**Consultation Response from Ryan Kinder KC,  
Highways Development Management**

**2023/91405 Part of former St Luke's Hospital site, Blackmoorfoot Road, Crosland Moor,  
Huddersfield, HD4 5RA**

**Erection of foodstore (class E) with associated access, parking, servicing area and  
landscaping**

**Date Responded: 15/08/2024**

date August 2023  
status Planning  
scale 1:500 @ A3  
drawn KA checked BM  
job no. 2783 dwg no. P413 rev. D

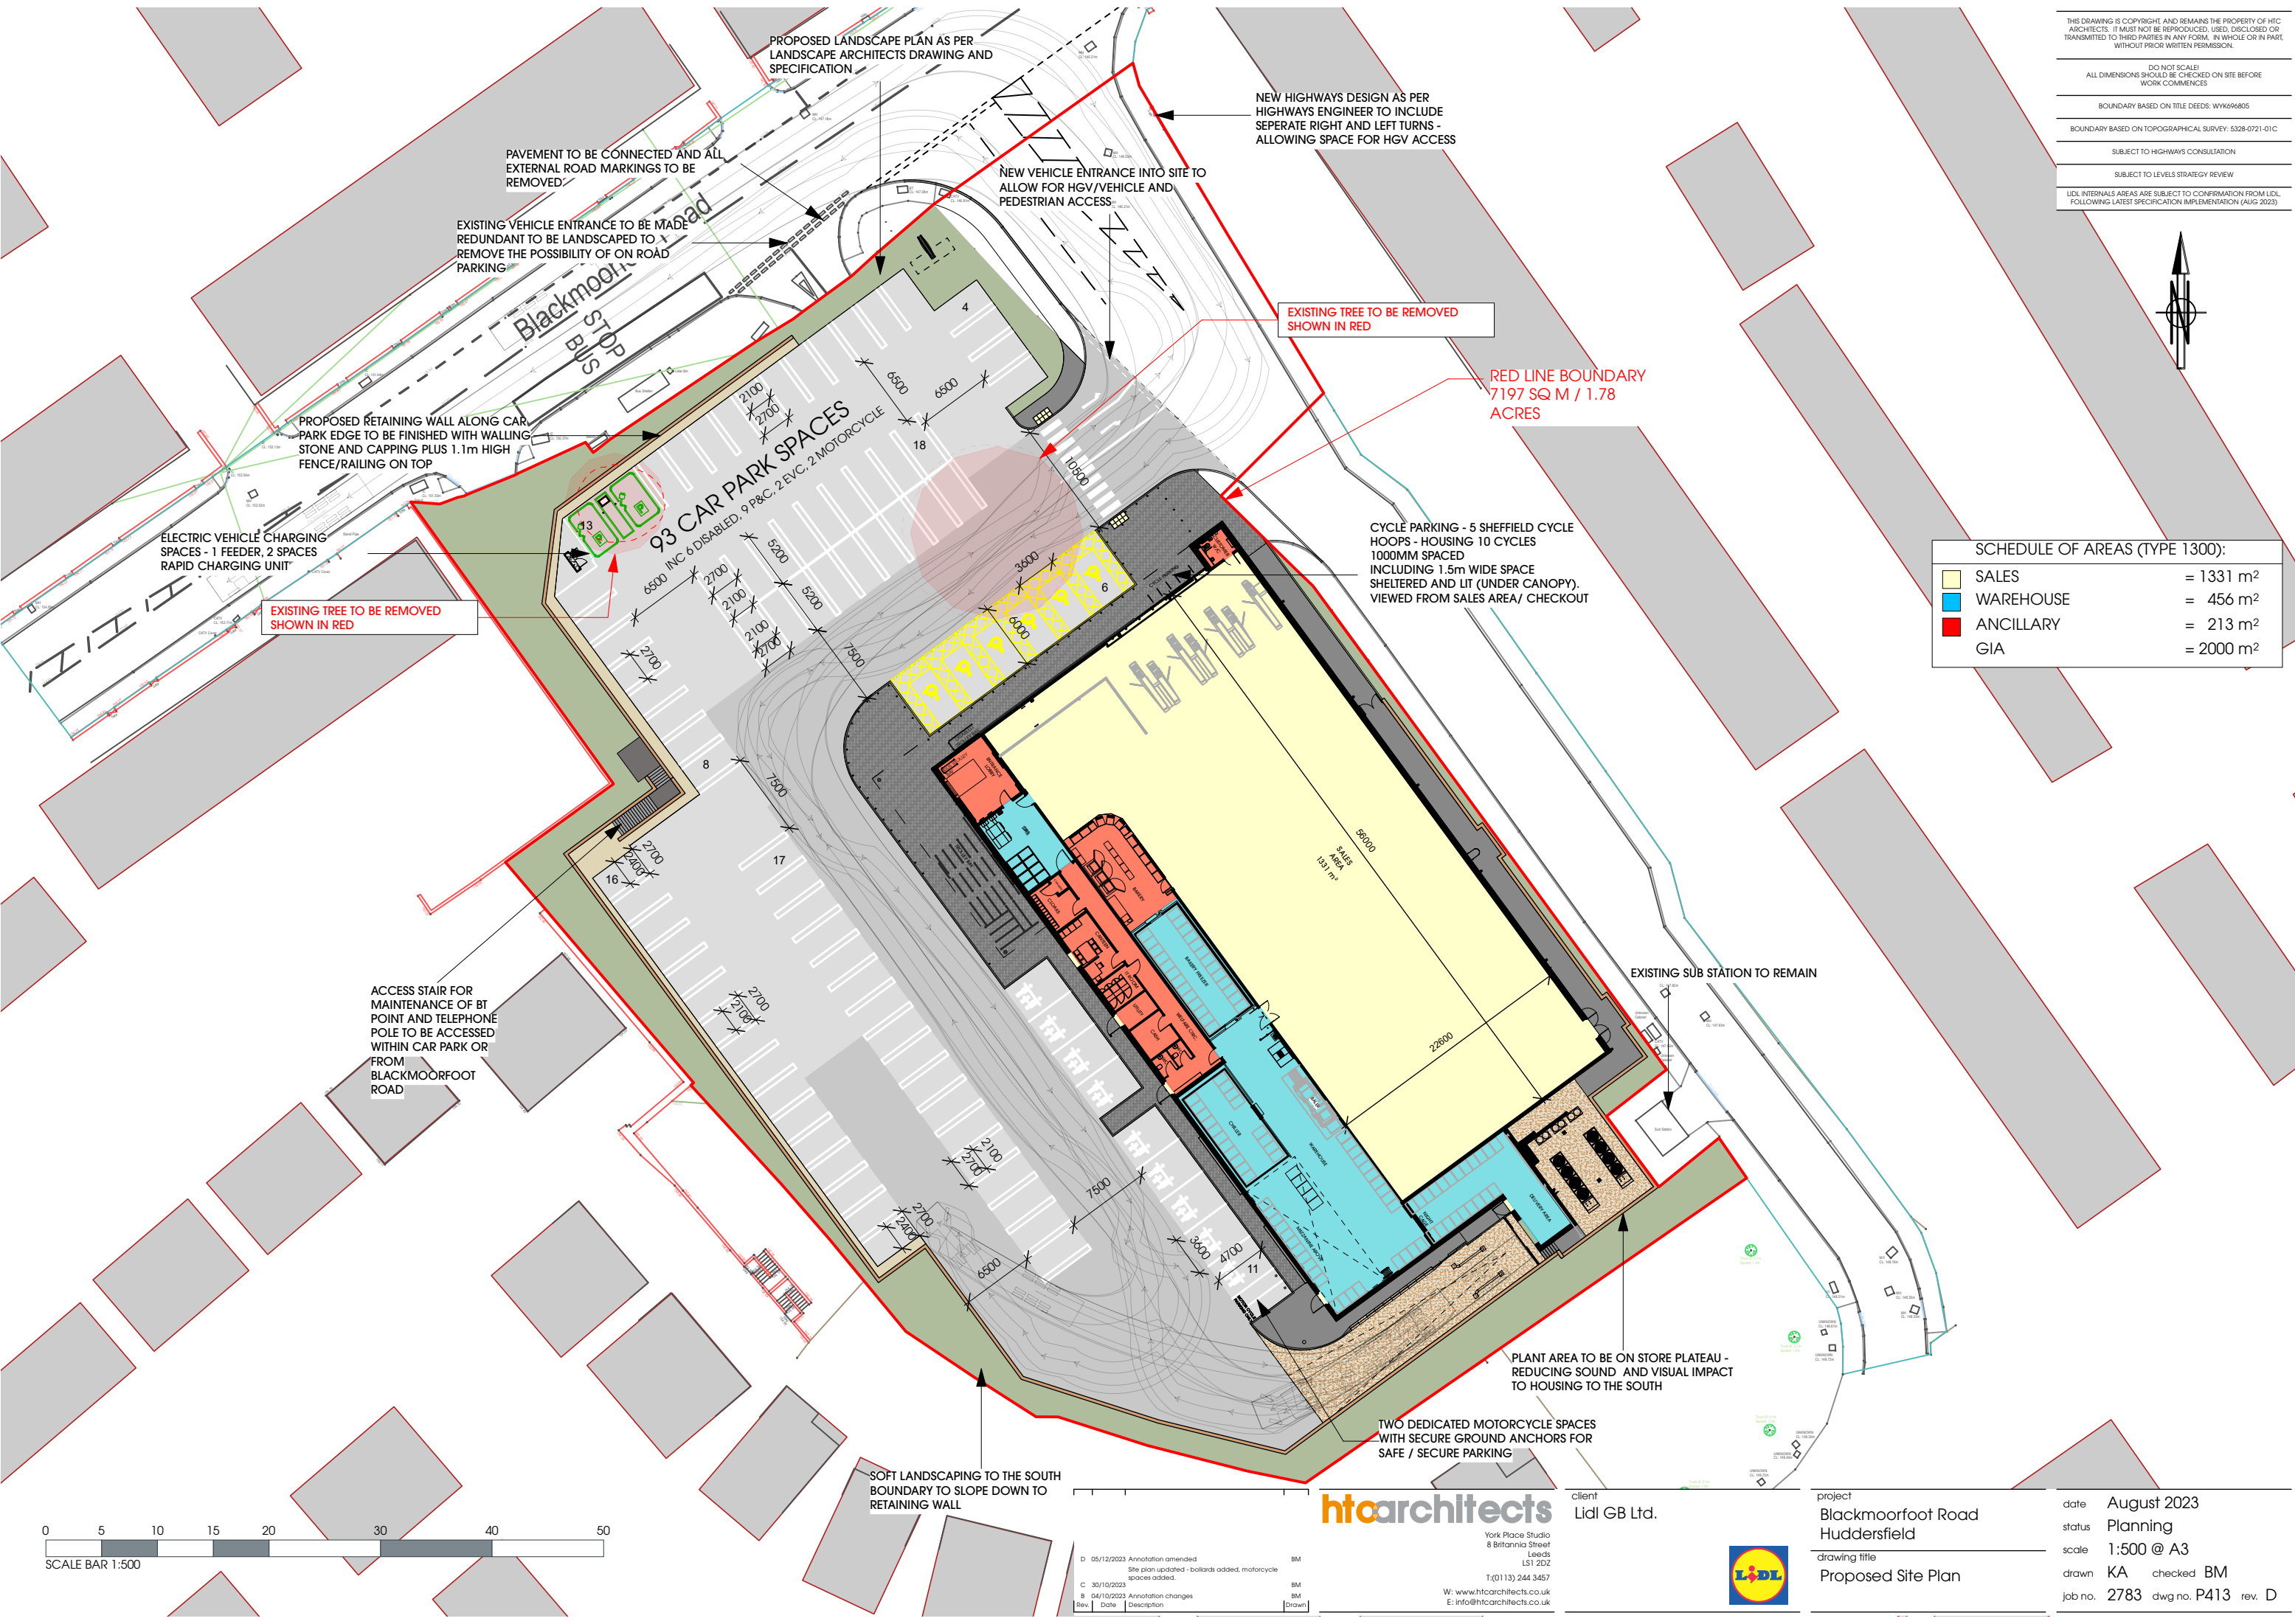
A priority giveway arrangement is proposed from the car park onto Turnstone way ref 2783/P413rev H, following ongoing discussions this proposal is now considered acceptable.

A priority giveway arrangement is proposed from the car park onto Turnstone way, the point of access is subject to review, it is suggested that the submitted indicative plan (ref R/2682/1A), where the site access is further away from the junction with Blackmoorfoot Road is the preferred option from a highway perspective to negate conflict with vehicle movements to and from the site and deliveries etc.

It is suggested that the internal layout be reverted back to the previous arrangement (ref R/2682/1A), this is preferred given the detail of the internal tracking of delivery vehicles. It is considered that there is less conflict with customer parking and ease of access to the loading bay. In addition the site access onto Turnstone Way is further away from the junction of Blackmoorfoot Road and will minimise conflict in this respect.
